Flyers Creek Windfarm – Technical Review of Supporting Documentation

- Final
- 12 July 2013

The Department of Planning and Infrastructure (DoPI) has requested that SKM provide expert advice in the field of Noise Impact Assessment for the Flyers Creek Wind Farm Environmental Assessment (EA) (Aurecon, May 2011), with respect to various draft Response to Submissions.

Figure A-1: Site plan showing monitoring locations and met mast locations.

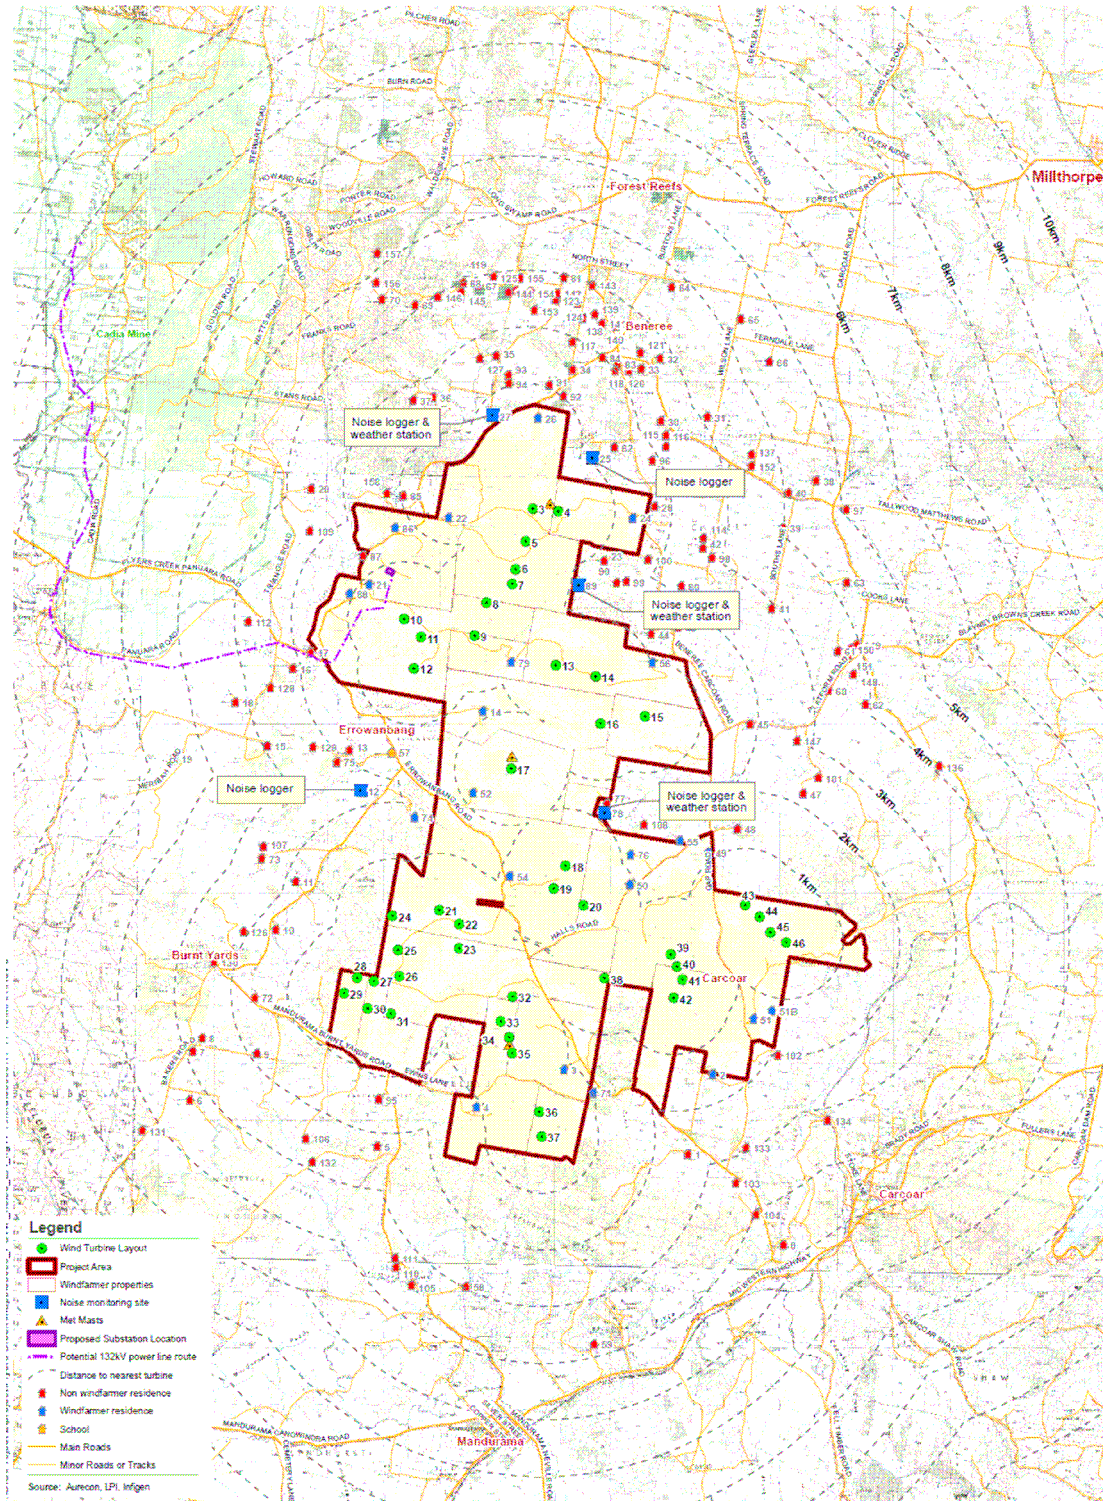
With respect to wind speeds at representative hub height, the statement is made that there were three masts and that there was only a small difference between average wind speeds between these masts. More information needs to be provided to justify this statement and to support the use of the central mast wind speeds for all locations. Greater simplicity is not in itself a justification. The discussion in Chapter 12.6.2 of the Environmental Assessment provides more information than the Vipac report! Why is this the case? In Section 12.6.2 it states that the southern mast was less suitable? This contradicts the implication of the Vipac background noise level report that suggests all masts were equally good?

**Loc 12 Background Noise at Receiver vs Wind Speed at Windfarm
78.6m AGL Total Regression**

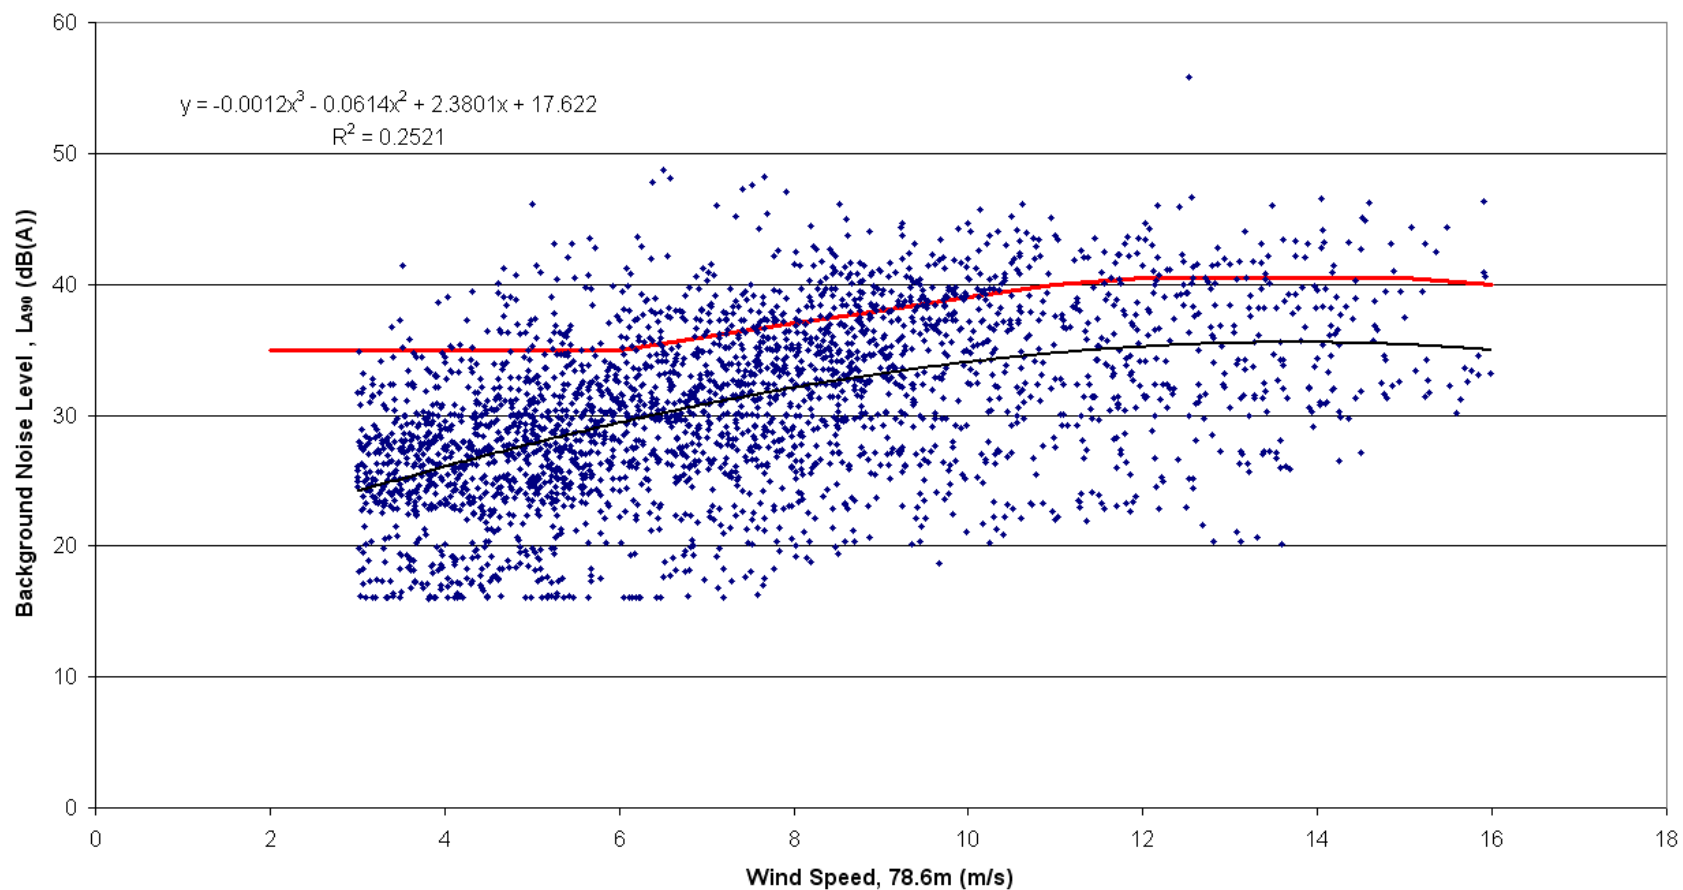
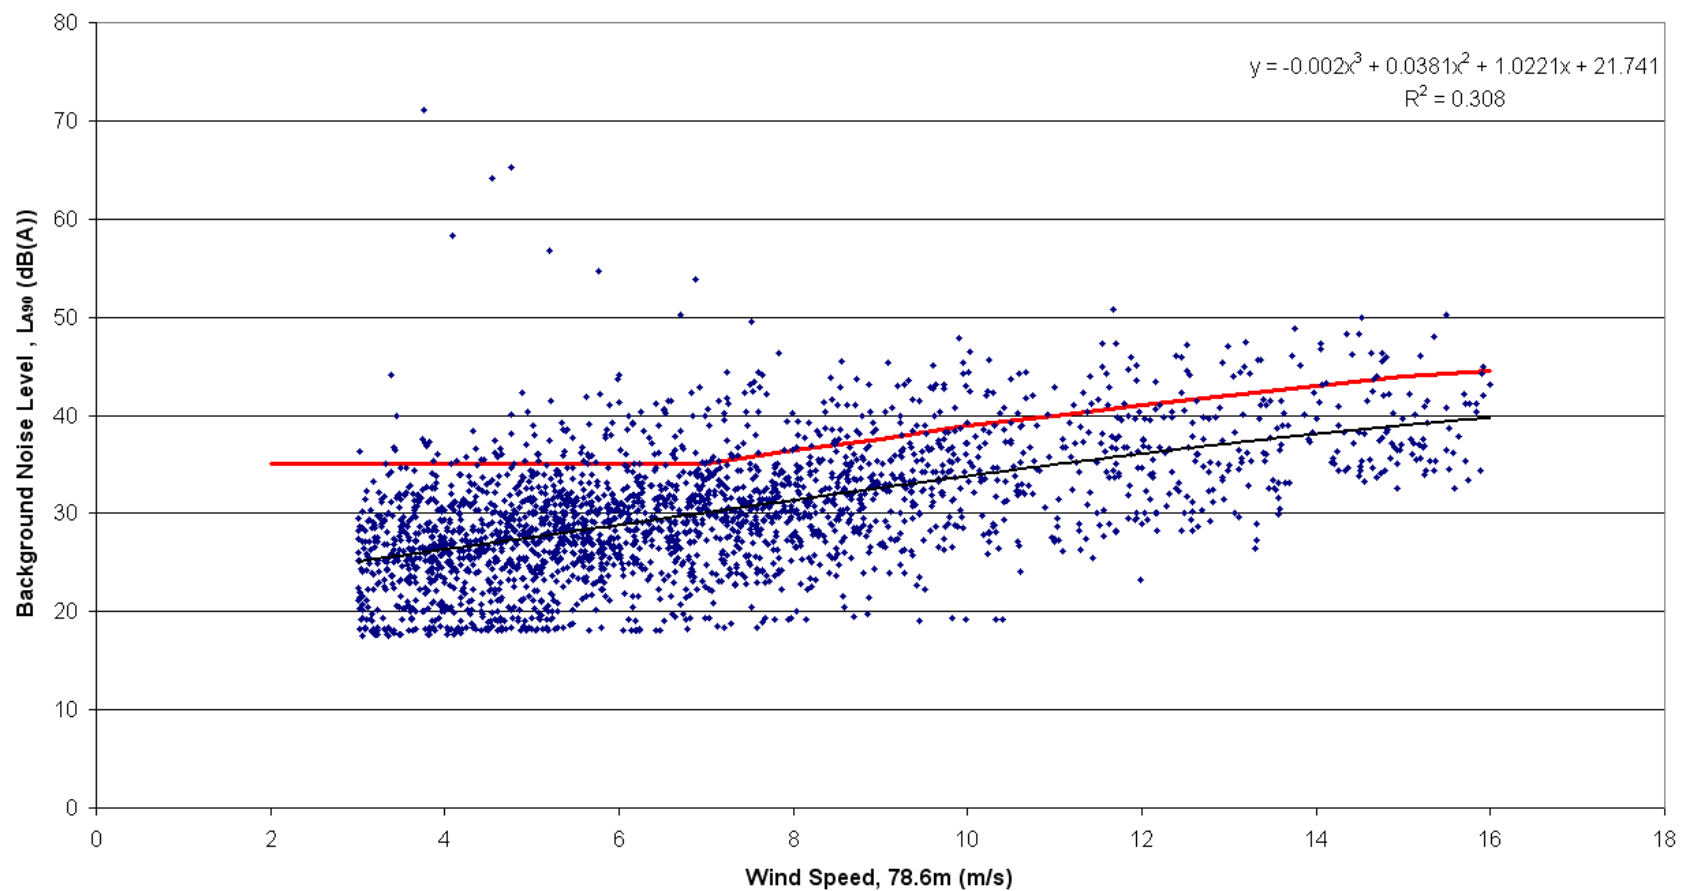
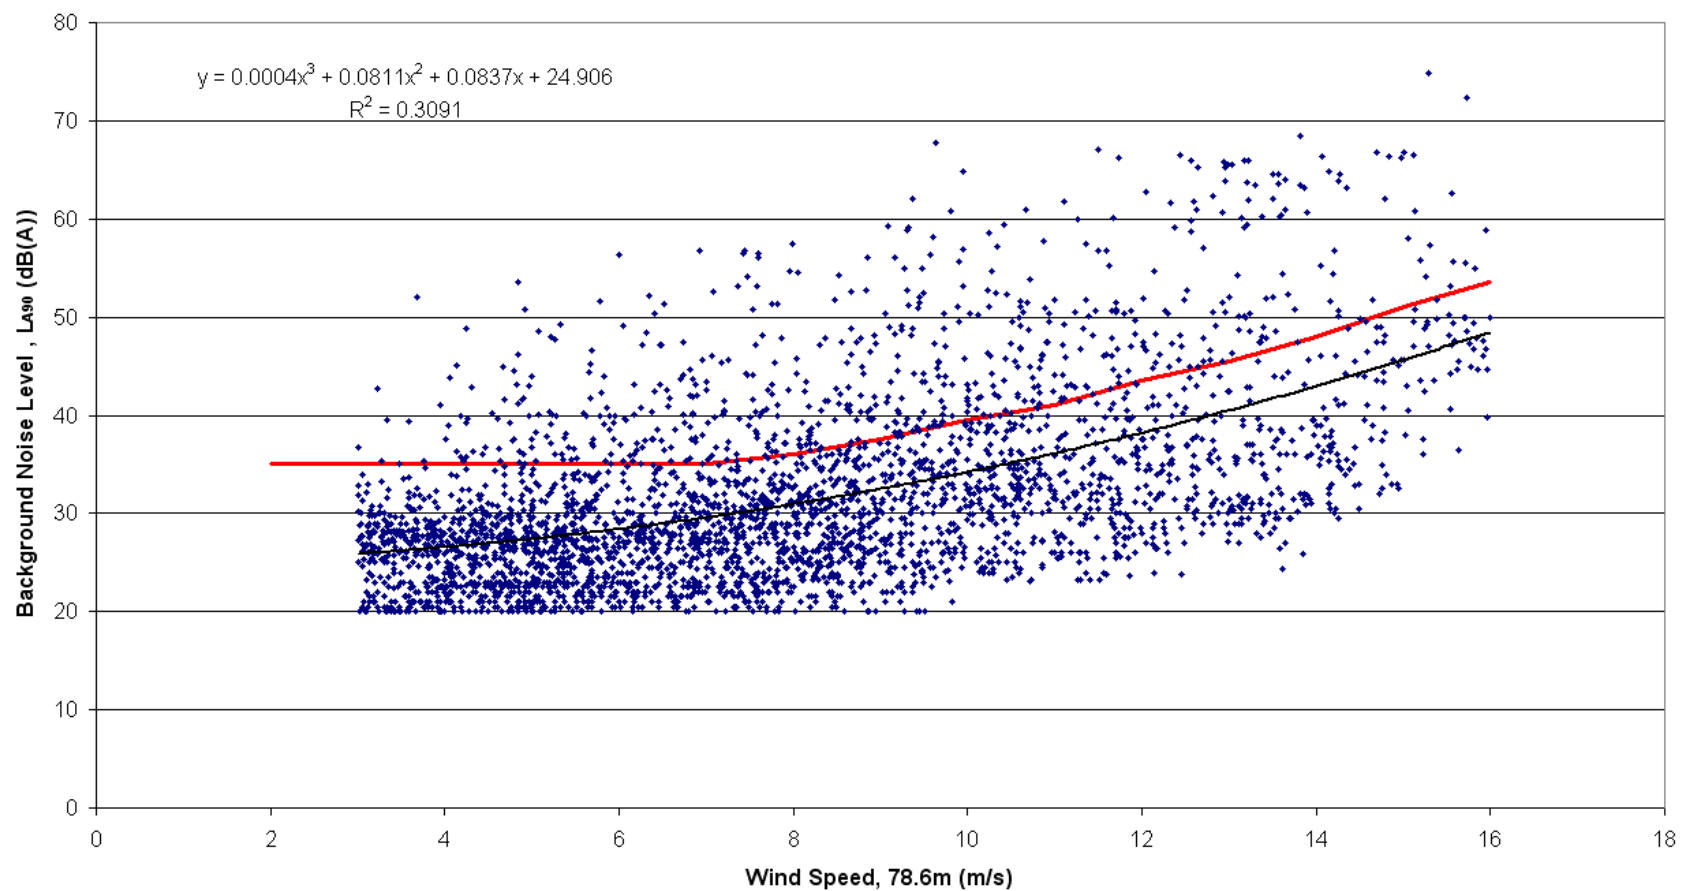
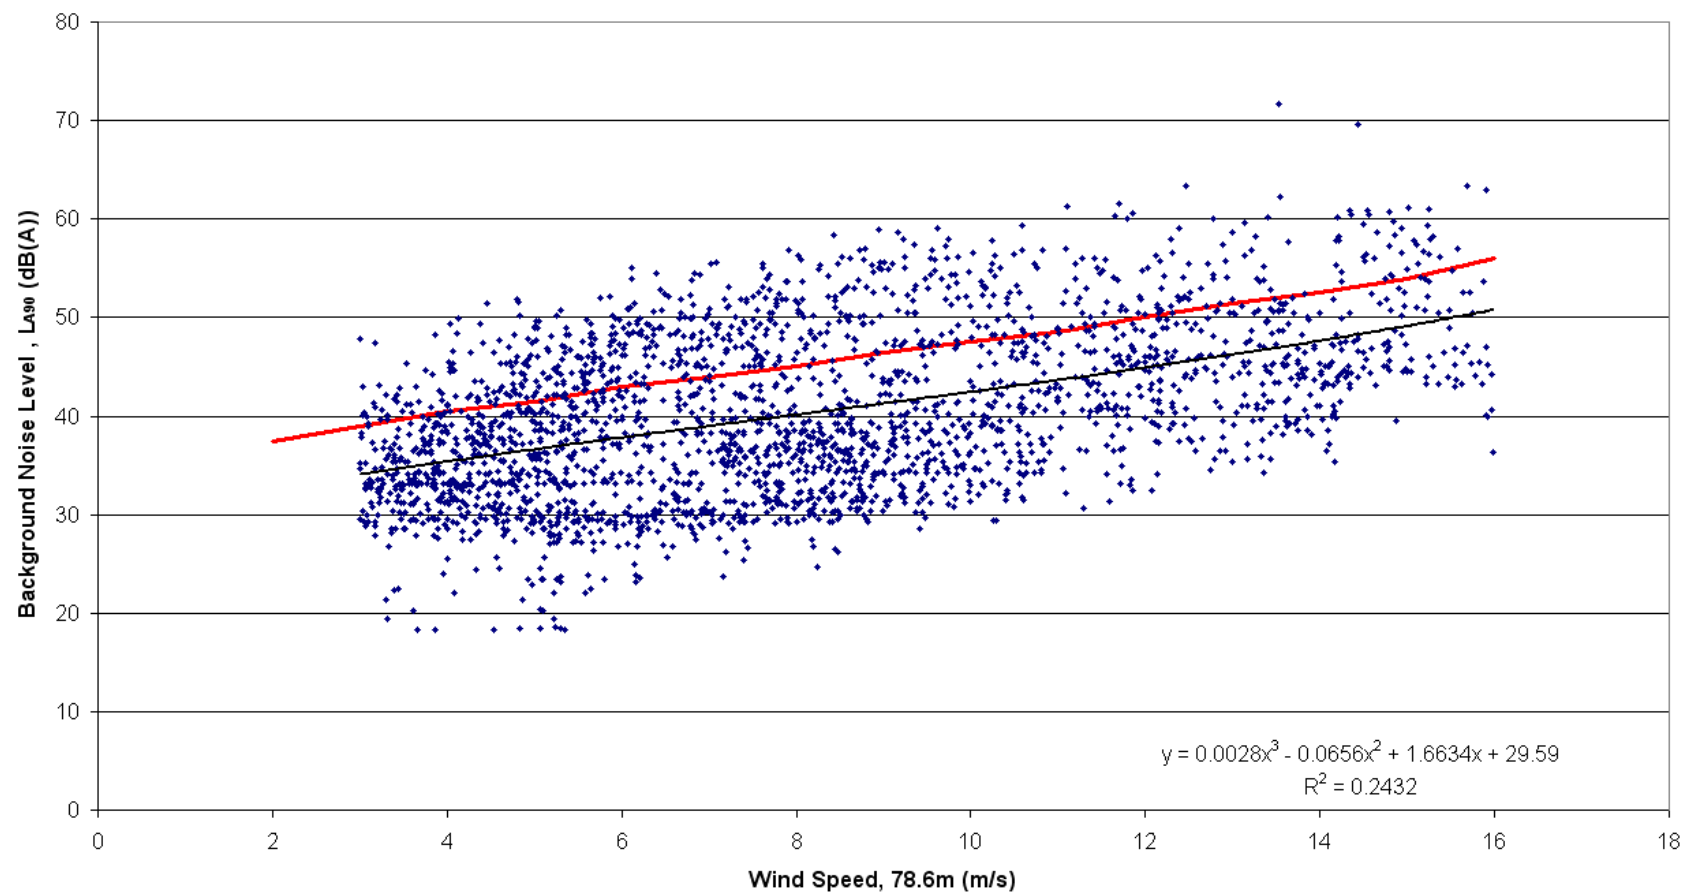
Table 5-2 heading refers to 78.6m AGL reference. The next line states Wind Speed at 76m AGL? In Chapter 12 Noise of the EA, on page 12-7, refers to 80 metre high monitoring masts?

SA03 requires that the correlation co-efficient should be specified for each polynomial up to the third order from the linear and that the best correlation coefficient should be used to provide the fitted line. These correlation coefficients should be provided.
